**From:** Dawn Grocock [Dawn.Grocock@hertfordshire.gov.uk]  
**Sent:** 10 July 2015 14:24  
**To:** Mark Peacock  
**Subject:** RE: Consultation Invite: Land to the north east of King George V Playing Fields, Northaw Road East - PP-04267588 {-14644-0-}  
**Attachments:** Possible New Path & ROWIP Details Plan.bmp  
**Categories:** Printed by Planning Support

Application ID: S6/2015/1342/PP - Mr M Peacock Application Owner: Welwyn & Hatfield Borough Council(Development Management Officer)  
Applicant: Marrons Planning  
Location: Land to the north east of King George V Playing Fields, Northaw Road East - PP-04267588 Deadline Date: 24/07/2015 00:00:00  
Description: Outline Planning Application for residential development of up to 121 dwellings, associated infrastructure and a change of use from agricultural land to an extension of the King George V playing field

Drawing file: 141386_A_51 Rev A - Prop Shared Cycleway-Footway Link_South Drive-A_51.pdf

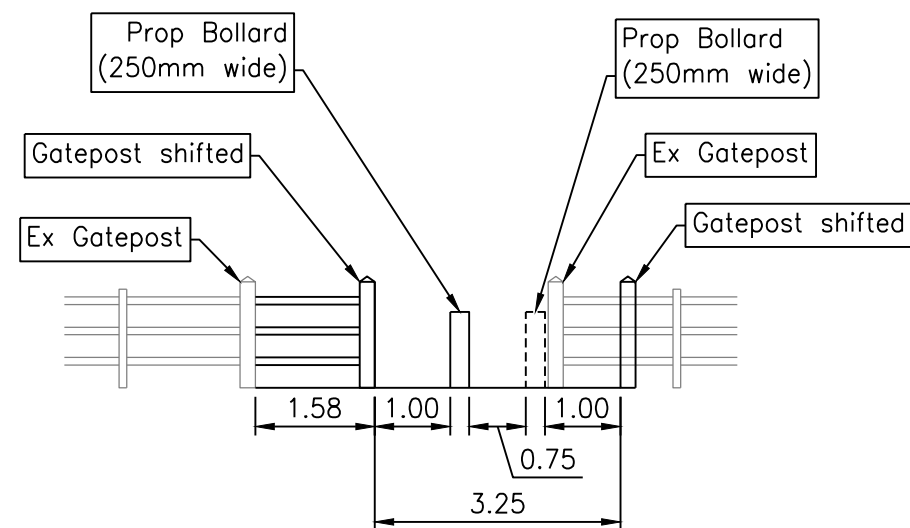
There is the possibility of local walkers submitting an application to record a path that was previously used between footpath 6 and South Drive, plan attached. Therefore including this route and dedicating it as a public right of way is wise. However, if they are looking for cycle use on this route as well, then it would need to be dedicated as a public bridleway, so it appears on the Definitive Map. Otherwise if they wish to only have a cycleway, then this can be discussed with Hertfordshire Highways. As with a bridleway, though this route would need to link to road or public right of way of the same or higher status, rather than public footpath 6.
